An
Coimisiún
Pleanála

Direction
ACP-322821-25

WHEREAS a question has arisen as to whether an extension to the rear of a dwellinghouse at 8 Clonmore, Kilteragh, Dooradoyle, County Limerick is or is not development or is or is not exempted development.

NOW THEREFORE An Coimisiún Pleanála, in exercise of the powers conferred on it by Section 5 (3)(a) of the Planning and Development Act, 2000, as amended, hereby decides that the proposed extension to the rear of a dwellinghouse at 8 Clonmore, Kilteragh, Dooradoyle, County Limerick is development and is not exempted development.

FLOOR PLAN & SITE LAYOUT PLAN

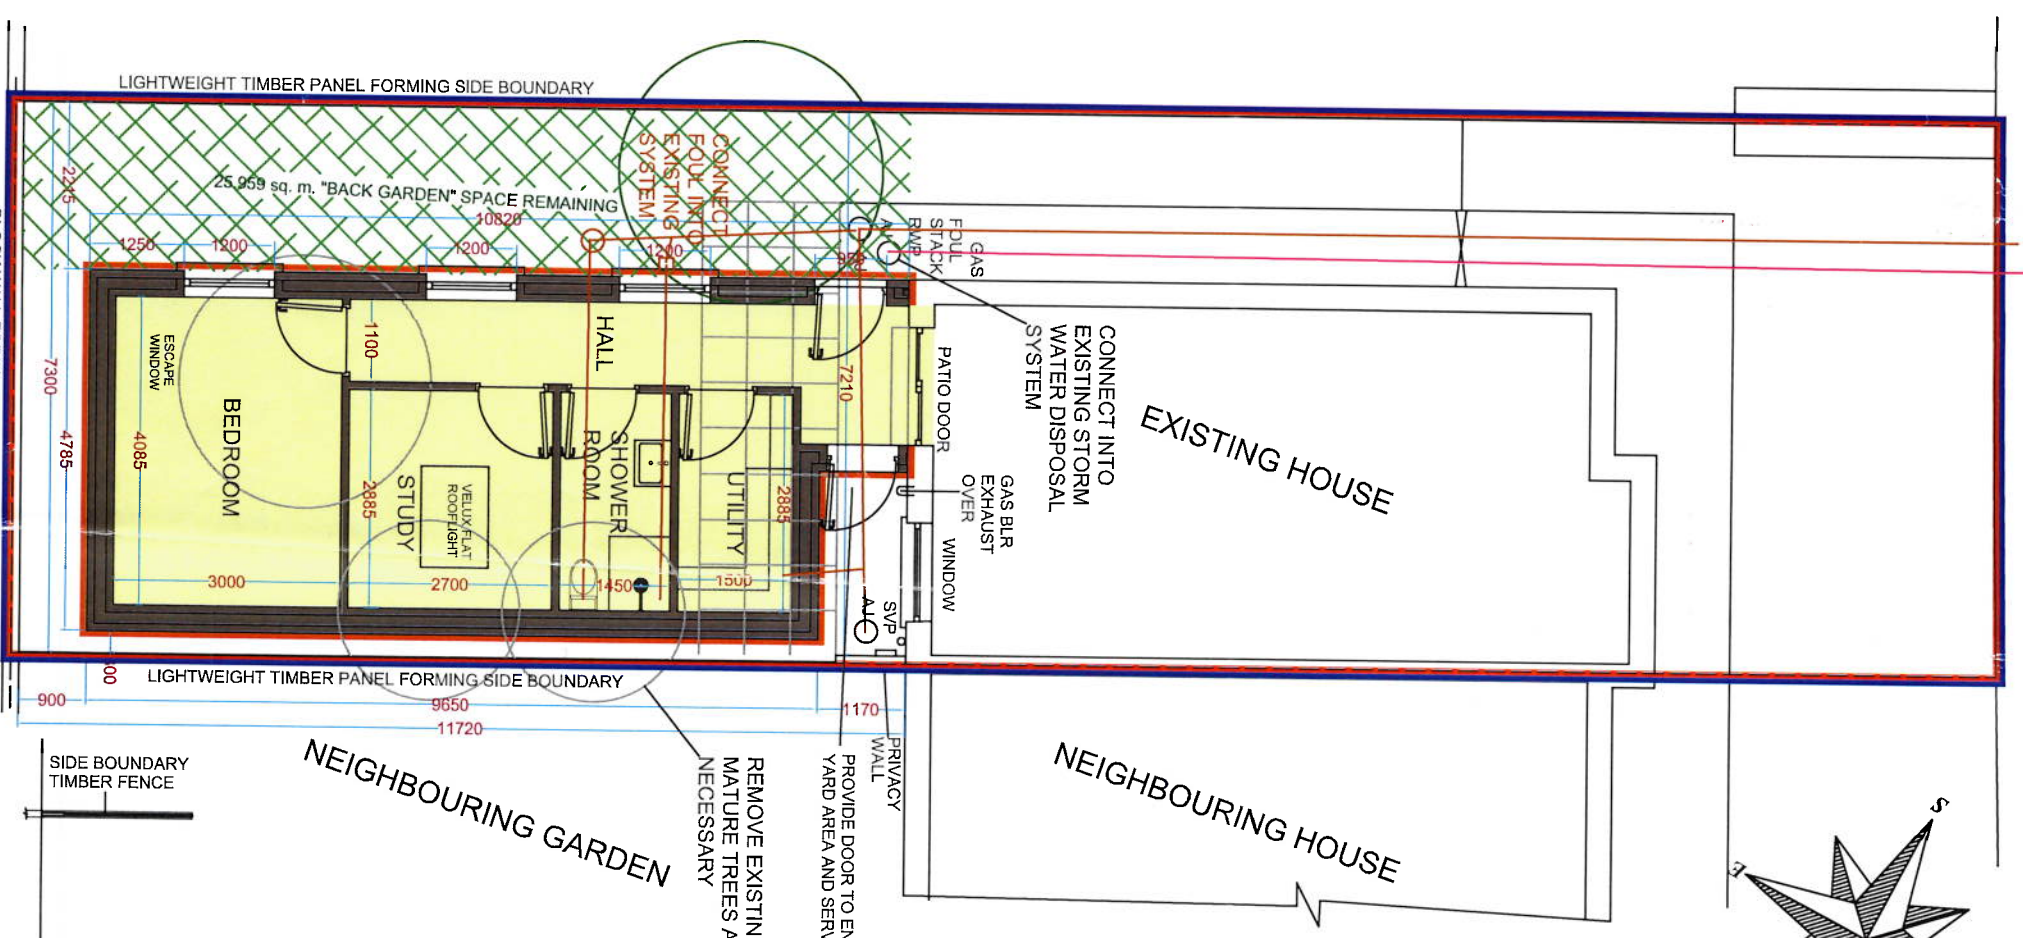
- (d) the floor area of the proposed extension does not exceed 40 square metres. Notwithstanding that there is an area of garden to the side of the proposed extension, the private open space, reserved exclusively for the use of the occupants of the house, remaining to the rear of the proposed extension would be reduced to less than 25 square metres,

- (e) the height of the extension does not exceed the height of the rear wall of the main house, and
- (f) the proposed extension, therefore, does not come within the scope of Schedule 2 Part 1 Class 1 of the Planning and Development Regulations 2001, as amended, as the private open space, reserved exclusively for the use of the

occupants of the house, remaining to the rear of the proposed extension would be reduced to less than 25 square metres,

In deciding not to accept the Inspectors recommendation the Commission considered that the wording of Schedule 2 Part 1, Class 1, Condition & limitation 5 '*The construction or erection of any such extension to the rear of the house shall not reduce the area of private open space, reserved exclusively for the use of the occupants of the house, to the rear of the house to less than 25 square metres*' did not refer to the open space to the rear of the original house or provide for the open space to be located to the side of the extension.
